**KIRKLEES METROPOLITAN COUNCIL
INVESTMENT & REGENERATION SERVICE**

DELEGATED DECISION TO DETERMINE PLANNING APPLICATIONS

Reference No:	2023/62/92652/E
Site Address:	64, Spen Valley Road, Ravensthorpe, Dewsbury, WF13 3EZ
Description:	Erection of single and two storey rear and single storey front extensions
Recommending Officer:	Jennifer Booth

DECISION - REFUSED

FIRST FLOOR PLAN

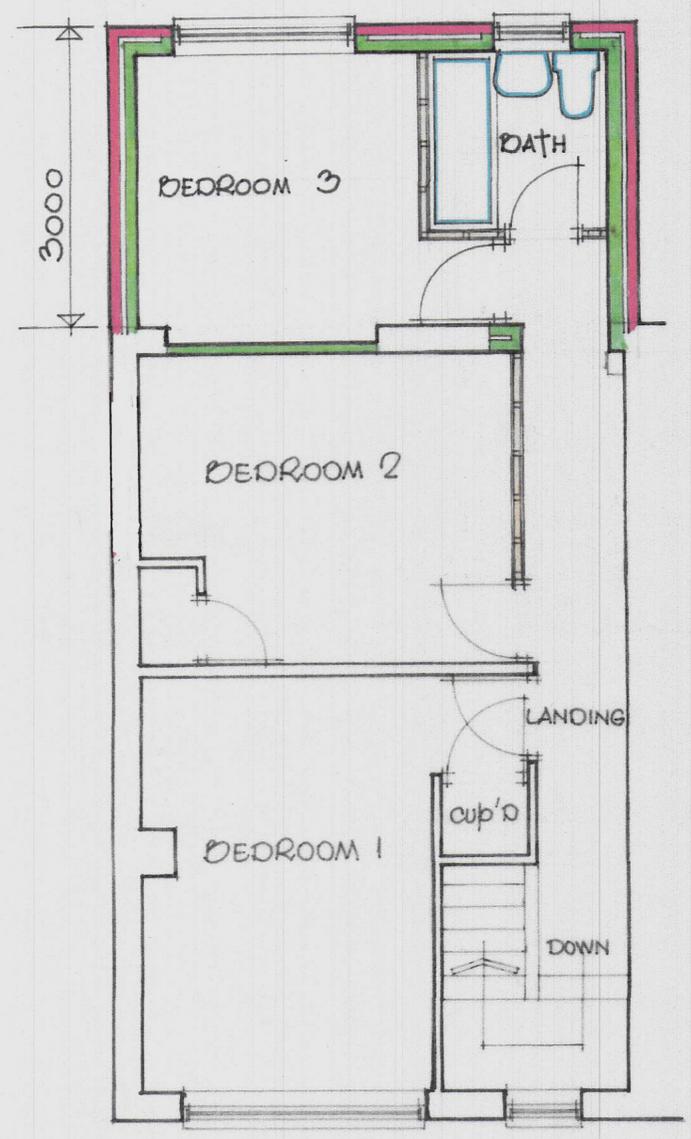
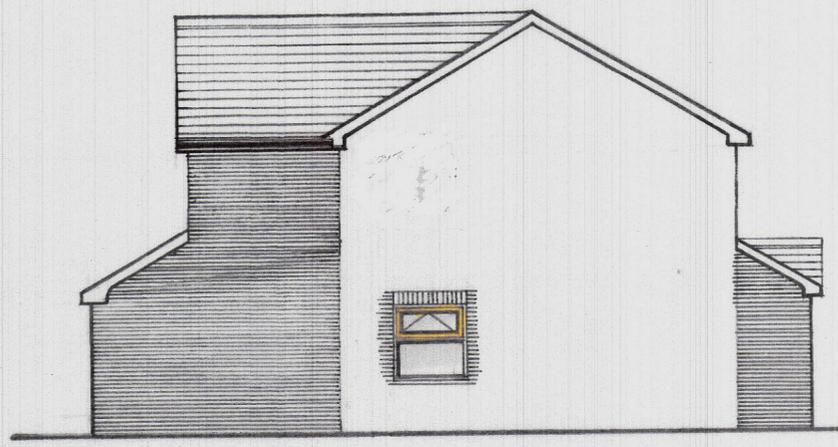
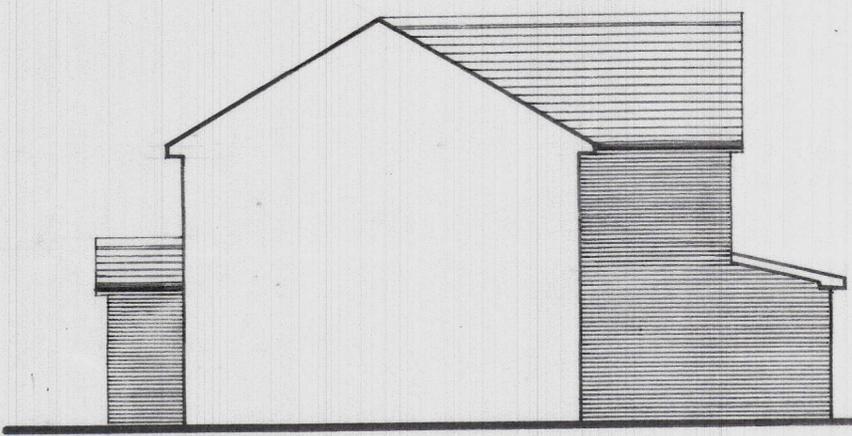
It is noted that a windows would be added to the side elevation of the host dwelling on the ground floor level serving the dining/kitchen. There would be no window to serve the first floor level serving bedroom 2.

The previously refused plans showed that there would be a window inserted to the side elevation of the host dwelling at first-floor level serving a bedroom (habitable space). Officers were concerned that this proposed window would have a close relationship to no.66, looking onto a blank wall at a distance of approximately 3.2m and that the separation distance was insufficient. The reason for refusals stated that the bedroom (habitable room) would experience restricted natural light and outlook which was unacceptable. The current application has removed the window entirely and has no opening whatsoever for the occupants of bedroom 2. The proposed development would therefore fail to provide a high standard of amenity for future occupants and would be contrary to LP24 of the Kirklees Local Plan, Key Design Principle 6 of the Council's House Extensions and Alterations SPD, and the aims of the National Planning Policy Framework.

After assessing the above factors, officers consider that this proposal would not provide an acceptable standard of living for future occupants. The proposal, therefore, fails to comply with LP24(b) of the Kirklees Local Plan, Key Design Principle 6 of the Council's House Extensions and Alterations SPD, and Paragraph 130 (f) of the National Planning Policy Framework.

The proposed occupant of bedroom 2 would experience substandard living conditions, given the lack of any window or opening which would prevent any form of natural light and outlook. The proposed development would therefore fail to provide a high standard of amenity for future occupants. To permit the proposed development would be contrary to LP24 of the Kirklees Local Plan, Key Design Principle 6 of the Council's House Extensions and Alterations SPD, and the aims of the National Planning Policy Framework.
